MERIDIAN STORAGE

LANDSCAPE PLAN

PPR2336      RESPONSE: REVISED

COUNTY FILE NUMBER:  
 PPR-2336

**PLANNING & COMMUNITY DEVELOPMENT DIRECTOR**

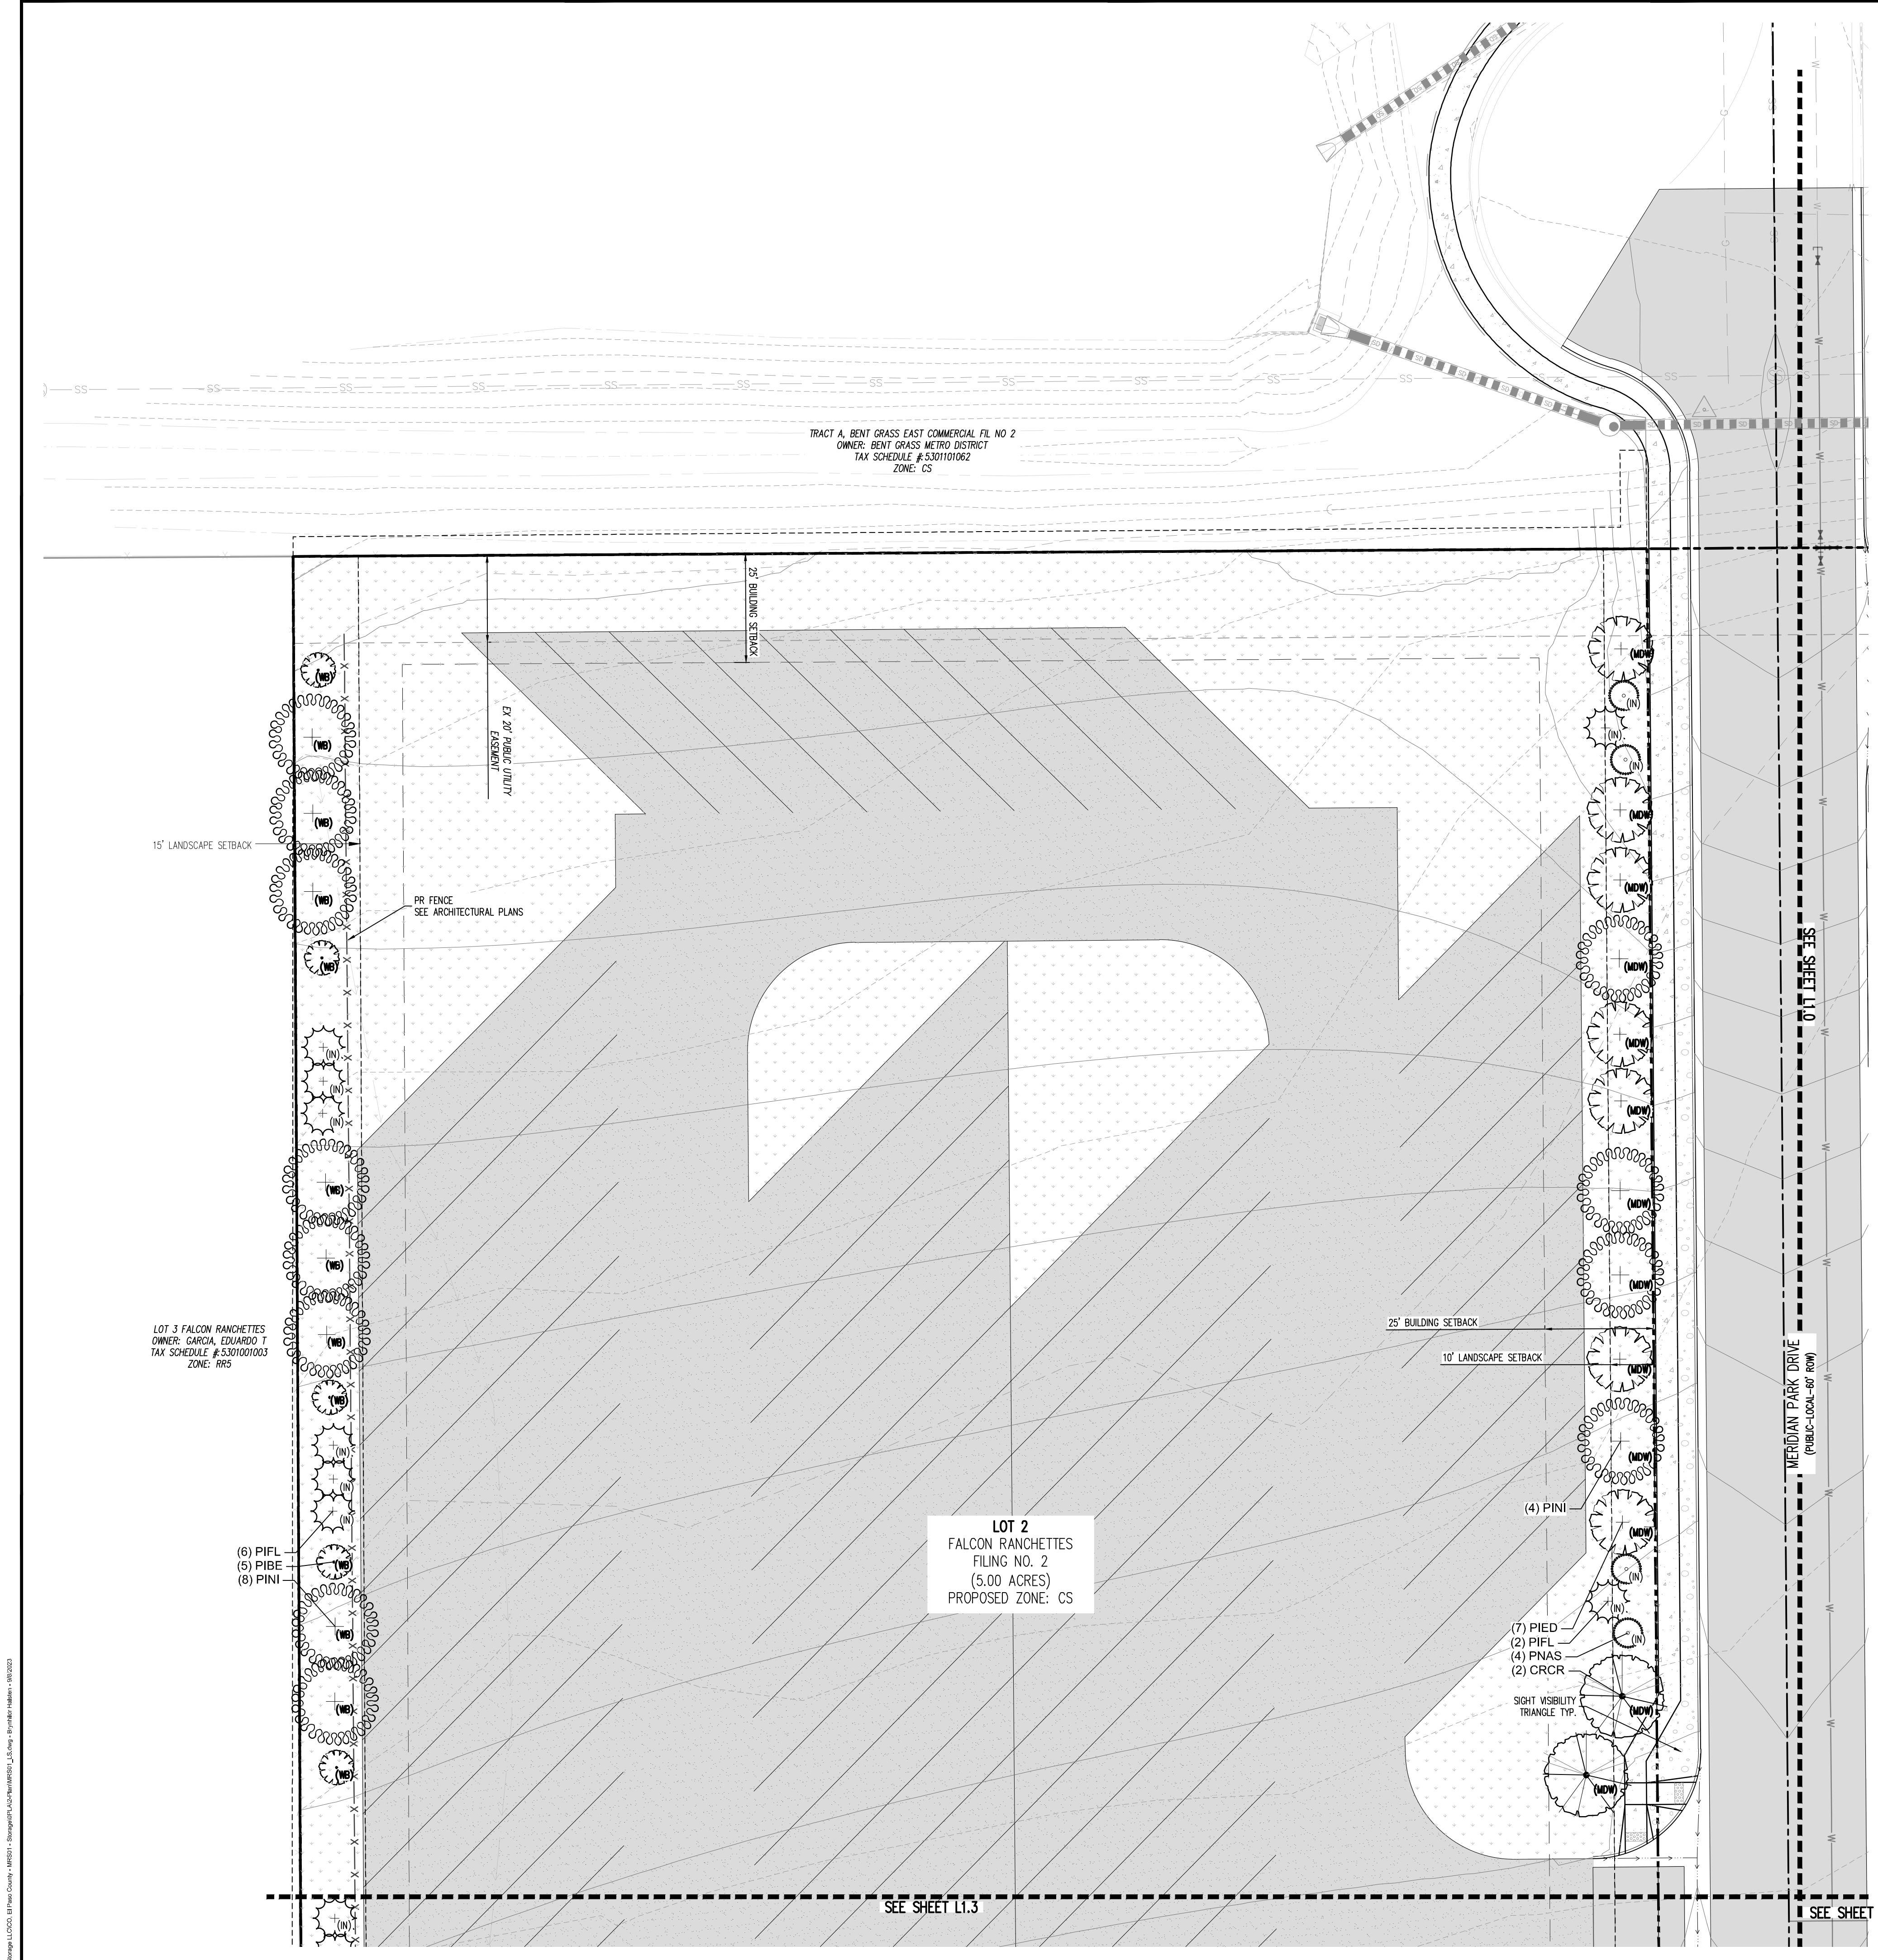
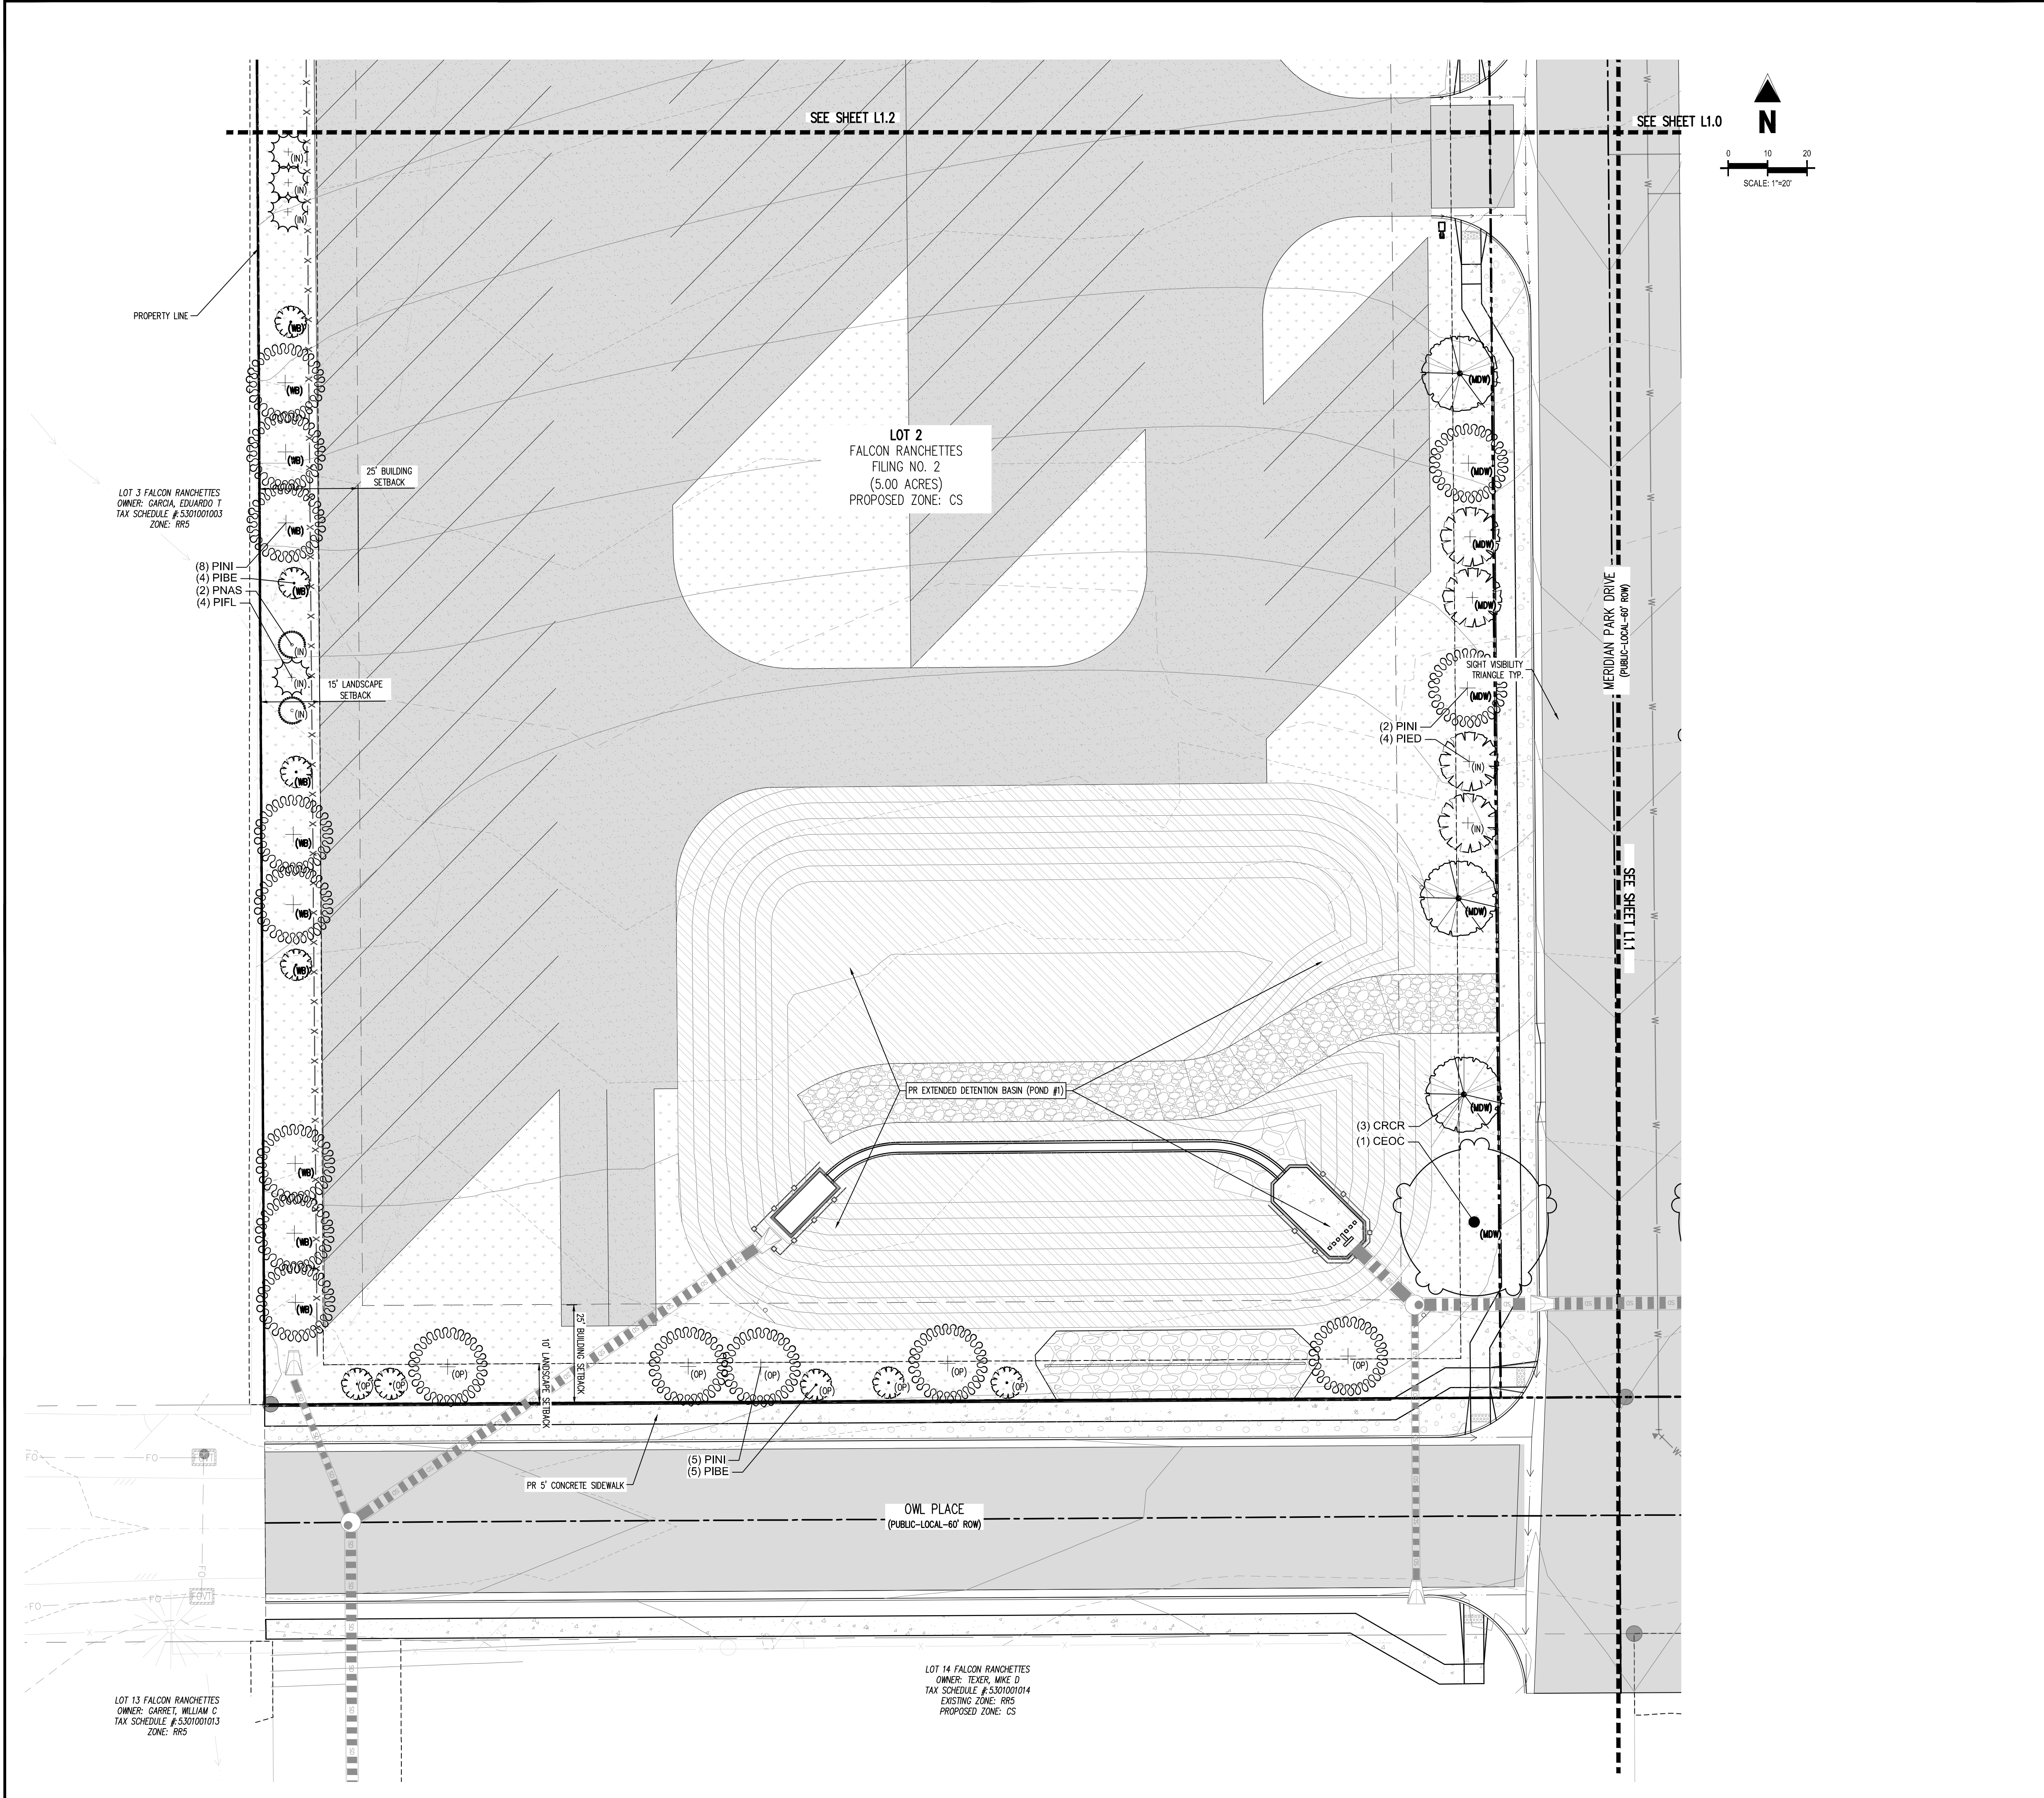
Lot 1 will still require fencing/screening per the code.

Can it be denoted where the screening/ gates will be in relation to the landscaping?  
 Can the height of the screening please be depicted as well?

RESPONSE: Lot 1 (self storage buildings) is adjacent to Commercially zoned properties and Meridian Road Right of Way. Meridian Road buffers from residential to east. No Screening required.

RESPONSE: PROPOSED EVERGREEN TREES WILL PROVIDE SCREENING
